**Application no: 23/02338/OUT**

**Location:** Land West Of Oxford Close And North Of Corner Farm, Station Road, Kirtlington

## Transport Schedule

TITLE:  
**Proposed Site Access -  
Vertical Visibility Splays**

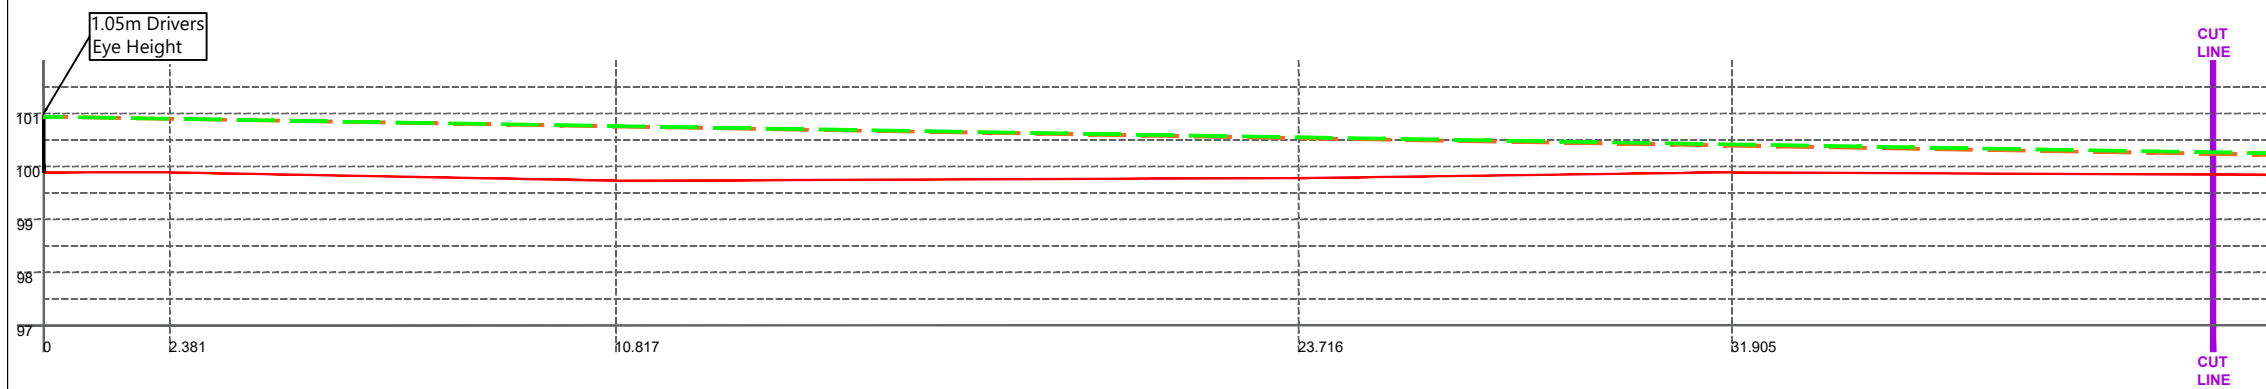
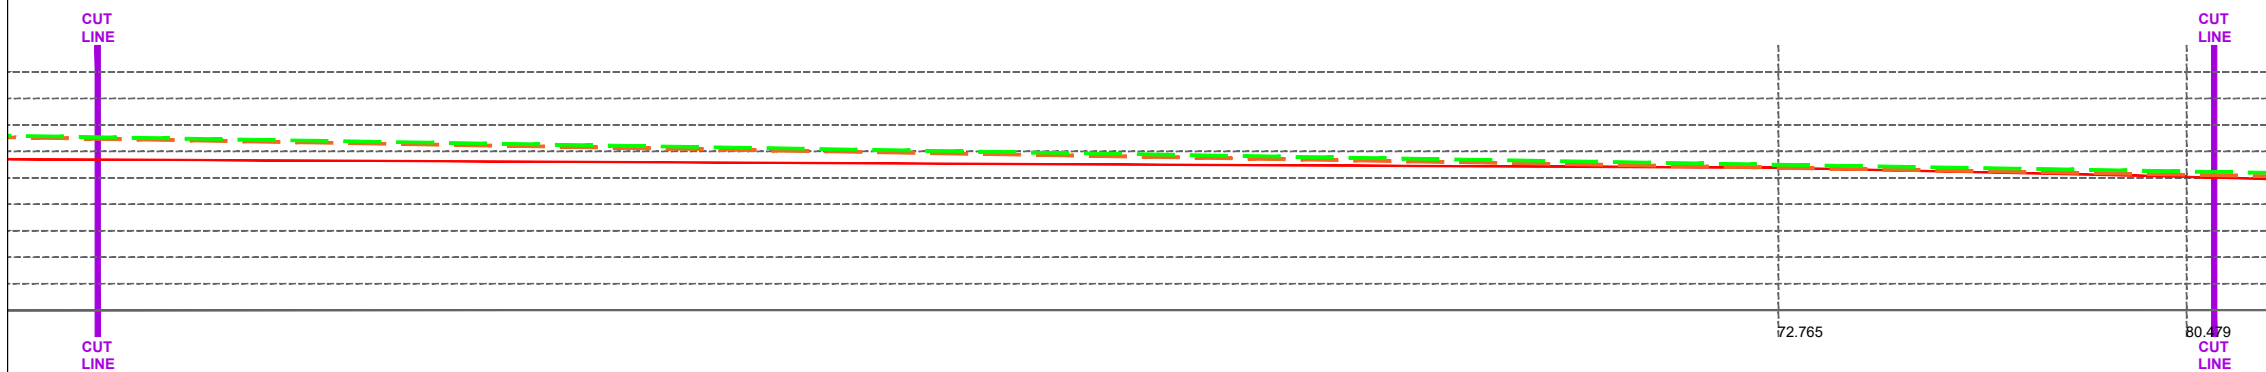
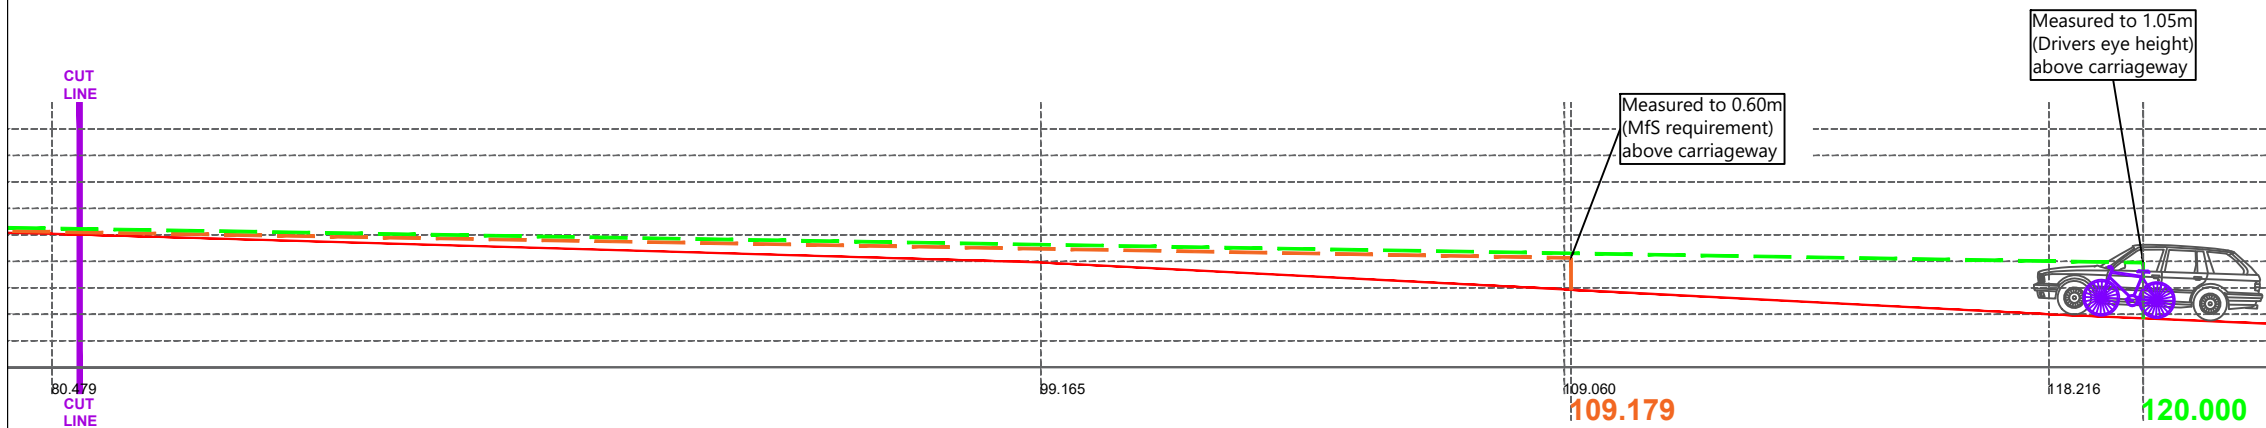
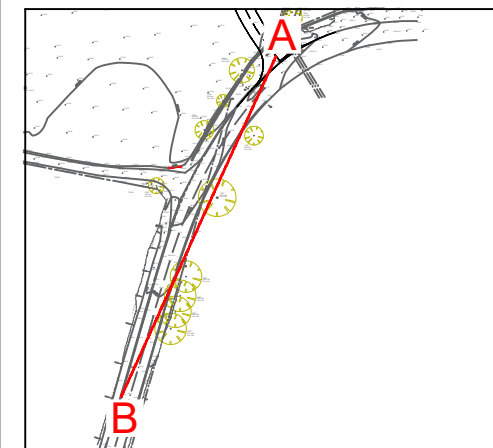
A further technical note has been provided, TN03, which includes a Road Safety Audit Stage 1. I am satisfied that the mitigation proposed, including a vehicle activated sign (speed limit reminder) and a village gateway feature, is sufficient. I support the proposed speed limit changes, which would be subject to further, statutory consultation. These would provide additional mitigation to ensure compliance with the speed limit on the approach to the proposed access.

It is recommended that the condition for details of the access includes specification and position of the village gateway feature and VAS. The applicant should contact OCC for advice on this prior to submitting the details.

No development shall commence unless and until full details of the means of access between the land and the highway, the footway connecting the development to the existing footway, and the village gateway feature and vehicle activated sign, including, position, layout, construction, drainage and vision splays, have been submitted to and approved in writing by the Local Planning Authority. The means of access, footway and village gateway feature shall be constructed in strict accordance with the approved details and shall be retained and maintained as such thereafter. Agreed vision splays shall be kept clear of obstructions higher than 0.6m at all times.
